Subject: Application for a non-material change in relation to the Victoria Embankment Foreshore (VCTEF) and Blackfriars Bridge Foreshore (BLABF) sites - PLA representation

The Thames Water Utilities Limited (Thames Tideway Tunnel) Order (SI:2014/2384)
Application for a non-material change in relation to the Victoria Embankment Foreshore (VCTEF)
and Blackfriars Bridge Foreshore (BLABF) sites

The Port of London Authority (PLA) has considered the above application by Bazalgette Tunnel Ltd dated 21-May-2020 and wishes to make the following representation:

Document Information
Application for Development Consent
 Extent of loss of listed river wall
 Sheet 2 of 2
 Book of plans - section 19
 DCO-PP-17X-BLABF-190023 - Rev 1
 May 2020

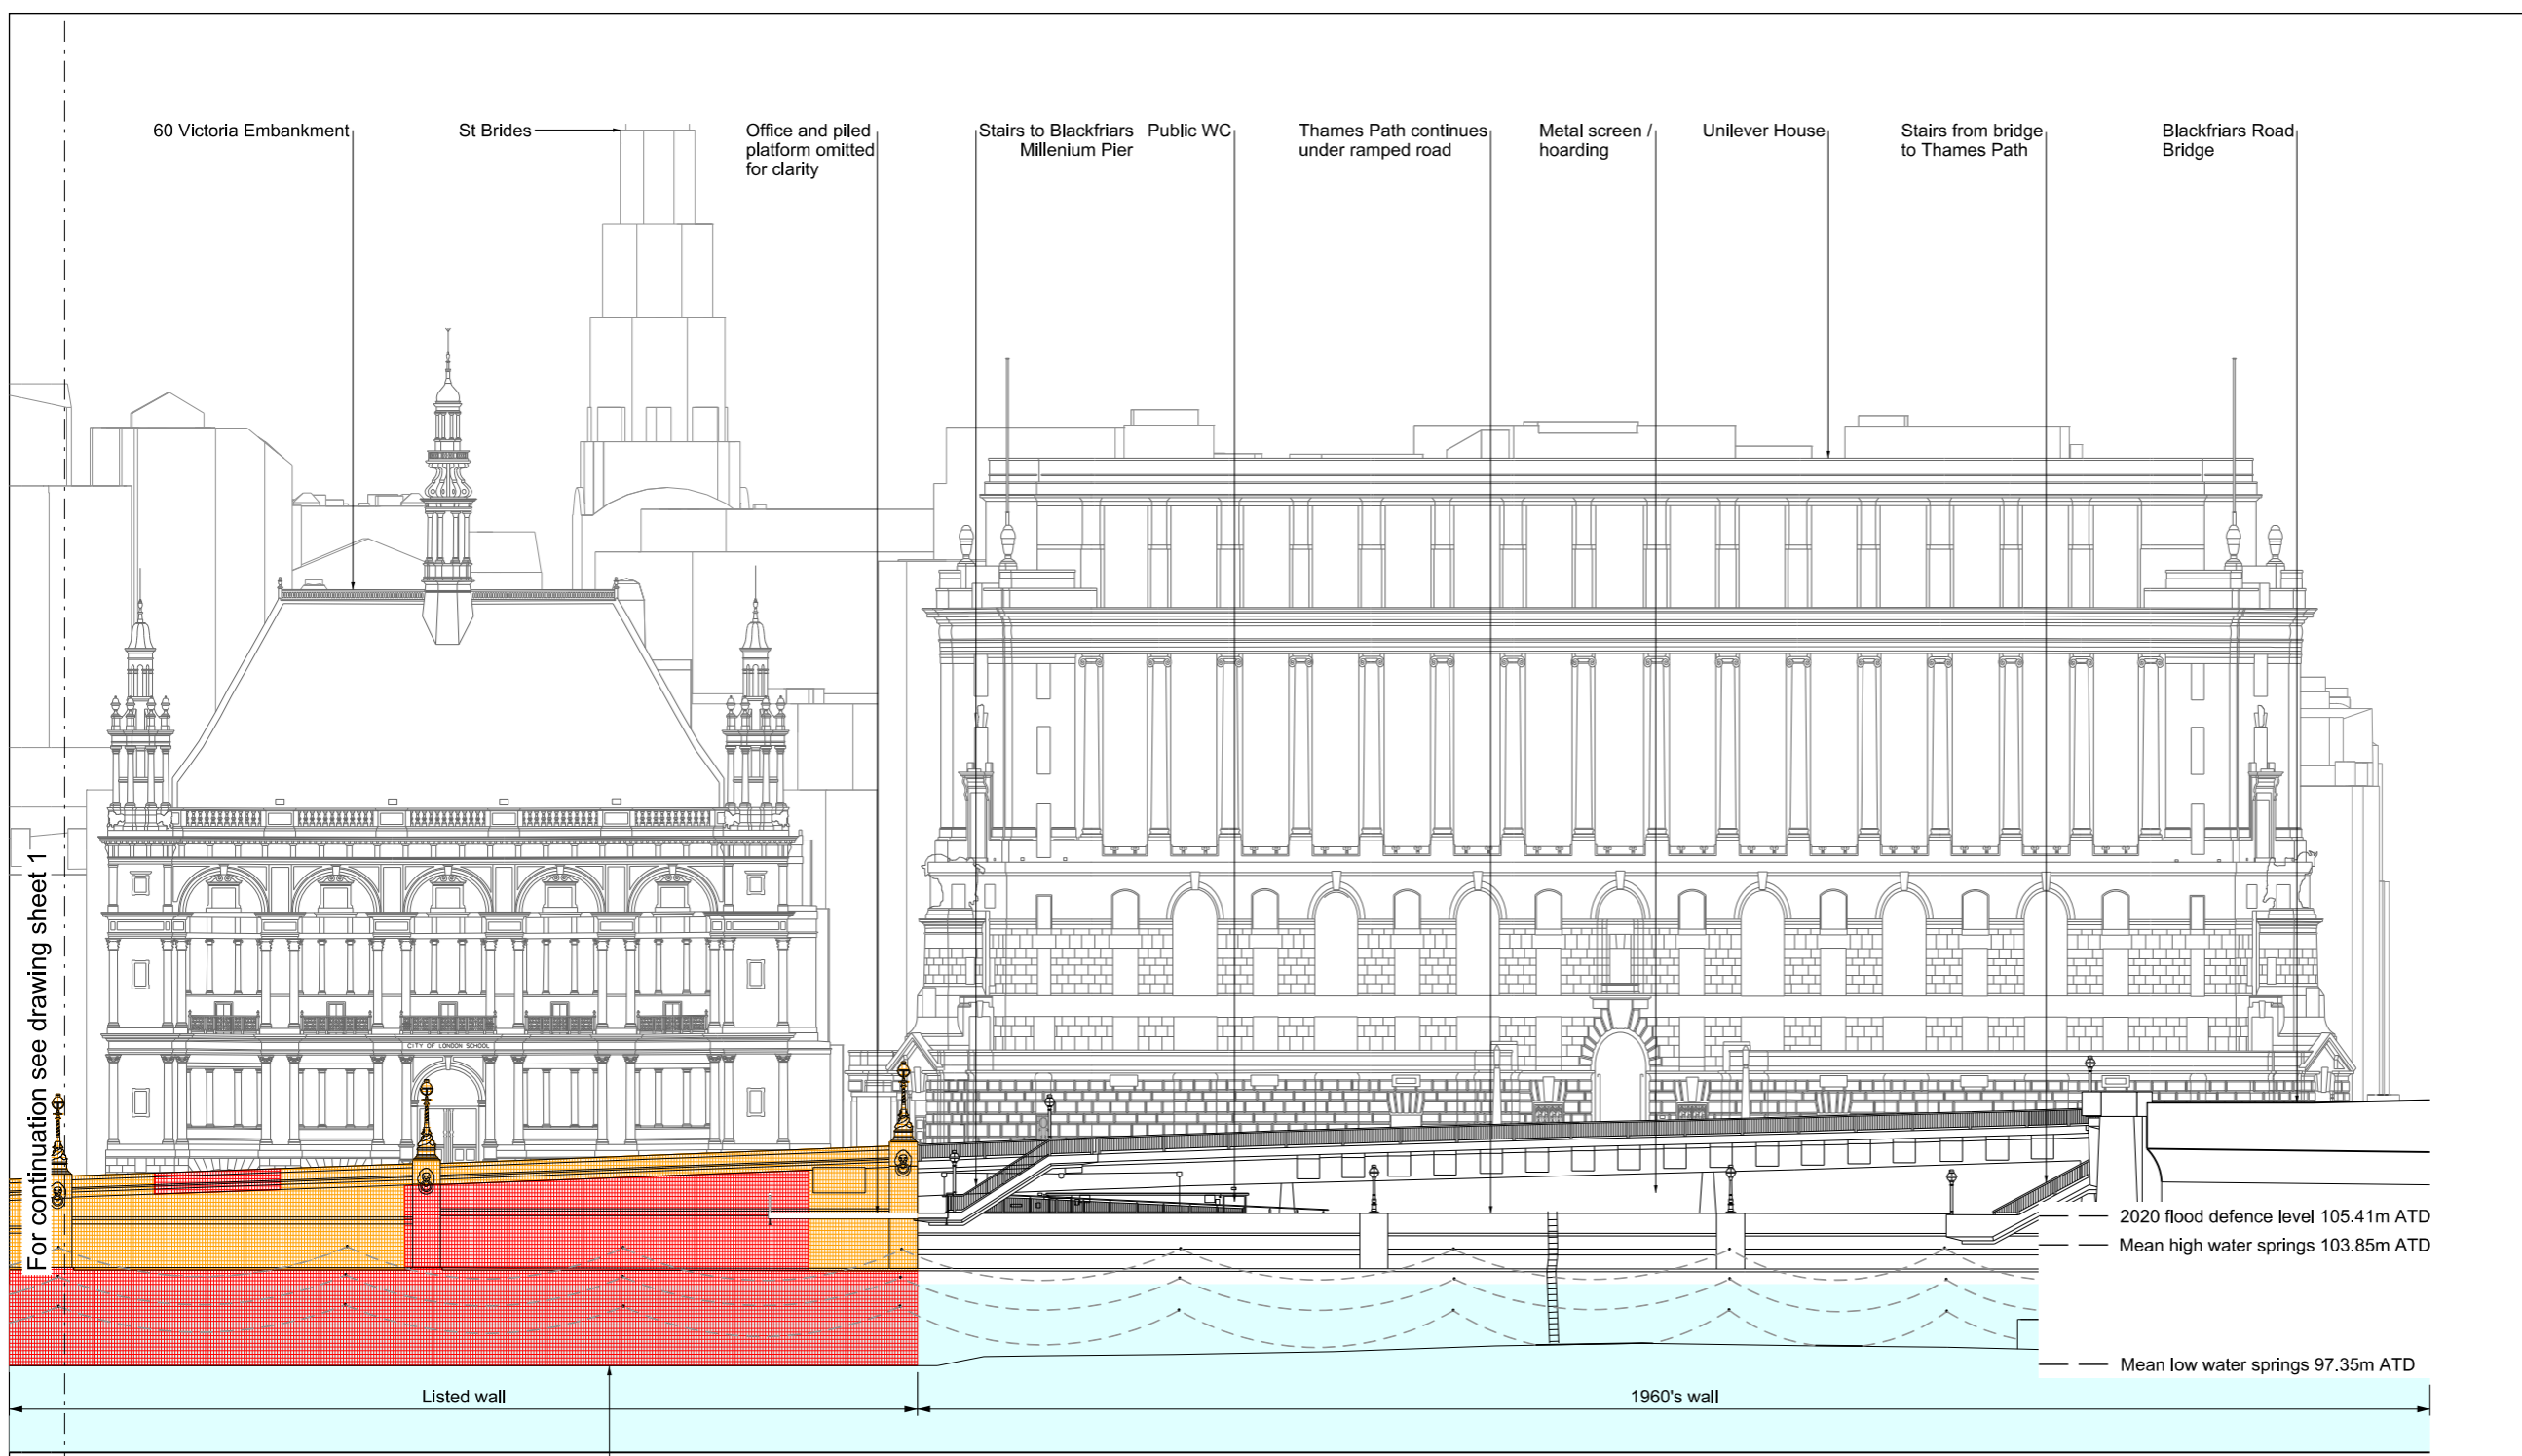
Noting the loss of an additional 80m² of listed riverwall, the PLA proposes that a suitable mitigation would be the retrieval and re-setting of the Bazalgette memorial stone, which is in the vicinity of the overflow weir chamber works, and was overlooked in the original assessment of effects on heritage assets.
